Please ask for: Sian Eggington
Email: sian.eggington@terraquest.co.uk
Telephone: 0121 2341390
Our Ref: WA/56/20/L
Your Ref:
Date: 6th October 2020

Listed Building Consent for Alterations, Extension or Demolition of a Listed Building

Development: Erection of a Shed and Car Port
Location: 5 Goodacres, West Gable Arundel Road Fontwell Walberton BN18 0SF

5 Goodacres, Arundel rd, Fontwell. BN18 0SF

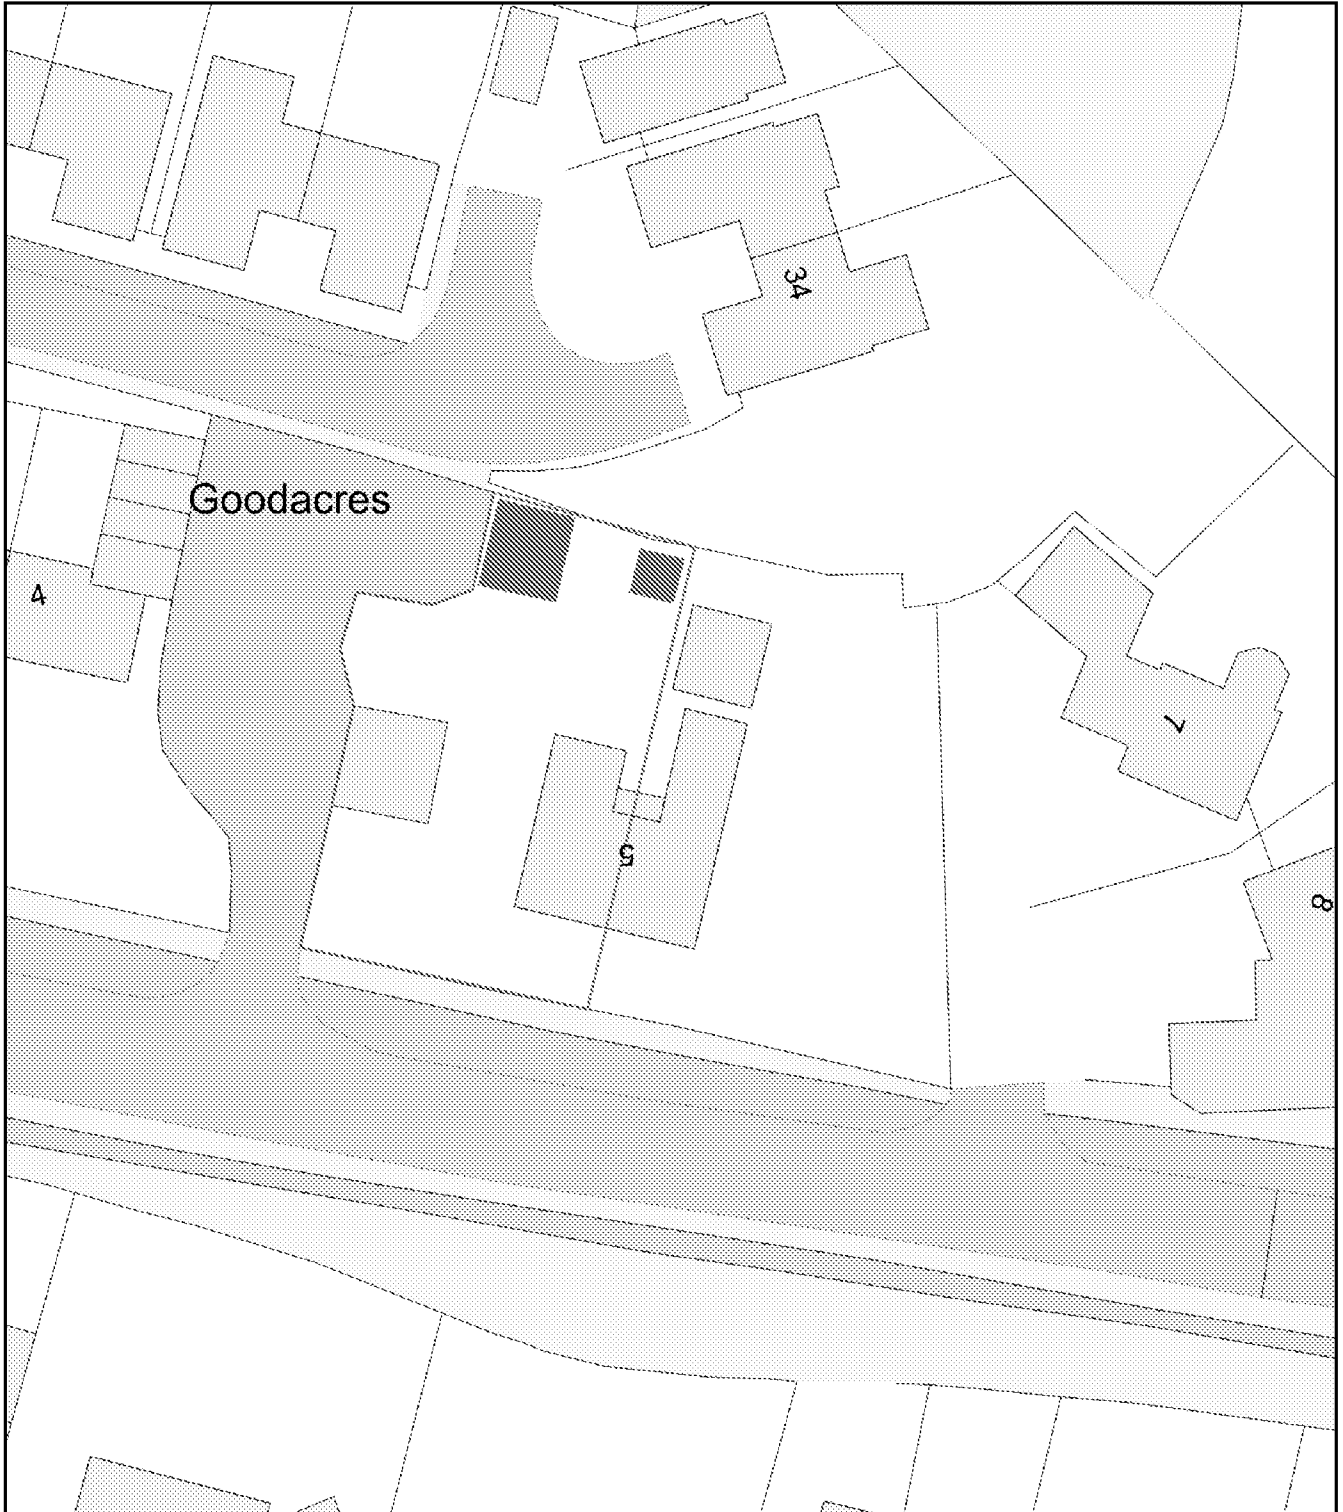
Block Plan

You are required to have dimensions from the proposed extension(s) to all site boundaries. Please amend.
